## **Boston Alternative Energy Facility**

Worst Case Assessment for Land Raising (Tracked)

Document Reference: 9.77 (1)

**Subject:** ~~Boston Alternative Energy Facility: Deadline 7 – Worst Case Assessment for Land Raising~~  
Boston Alternative Energy Facility: Deadline 9 - Worst Case Assessment for Land Raising

SECTION B-B
SCALE 1:100

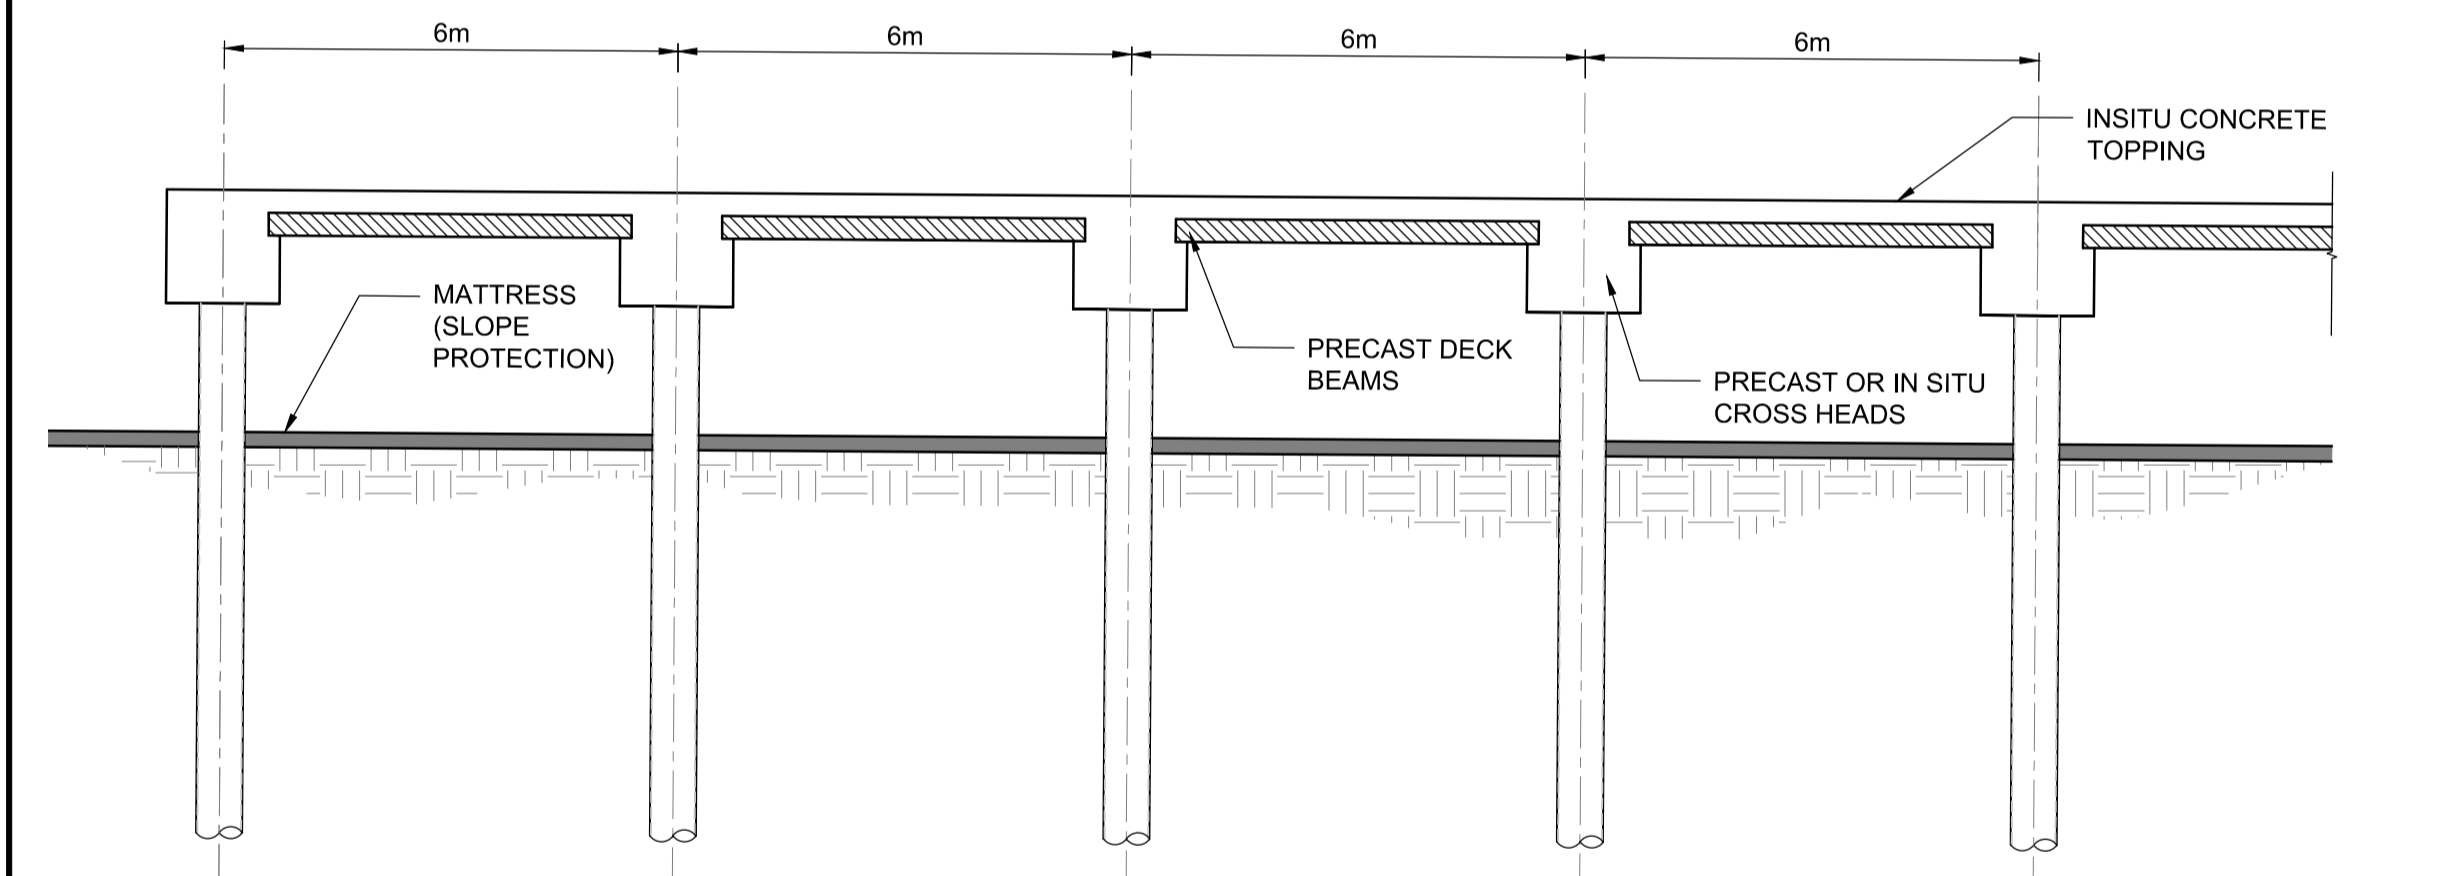
*2.4. We have reviewed document ref REP7-009 (Worst Case Assessment for Land Raising). We consider the document is a reasonable assessment of the possible impacts on flood flows as a result of land raising and has addressed some of our concerns. However, the assessment does not include an assessment of works taking place in the area between the proposed wharf and Roman Bank. The assessment must be updated to see what impact (if any) may arise as a result of works in this area.”*

4.1.3 Furthermore, it is noted that, in their Deadline 8 submission (REP8-019), the Environment Agency requested the same assessment be undertaken for the land between the proposed wharf and the Roman Bank. However, the Applicant notes that this part of the site has also been omitted from the assessment on the basis that the land in this location will not be subject to the same cut and fill exercise as the Principal Application Site.

4.1.4 Whilst it is acknowledged that the undeveloped site, comprising mainly agricultural land, may have some minor localised variations in topography (noting it is currently a relatively flat site) there is no proposal for a comprehensive cut and fill exercise to adjust the level of the land either up or down between the proposed wharf and the Roman Bank.

4.1.5 In addition, the proposed wharf is to be located to the riverward side and in line with the footprint of the existing defence extending inland only as far as the rear of the existing embankment. After this point there will be a drop in the level from the proposed wharf to the development behind so that it matches the existing ground levels to the rear of the existing defence.

4.1.24.1.6 It is on the basis of the above that the land between the proposed wharf and Roman Bank has been omitted from the assessment as no change in ground levels means there will be no reduction in flood storage in this location post-development compared with the existing scenario.
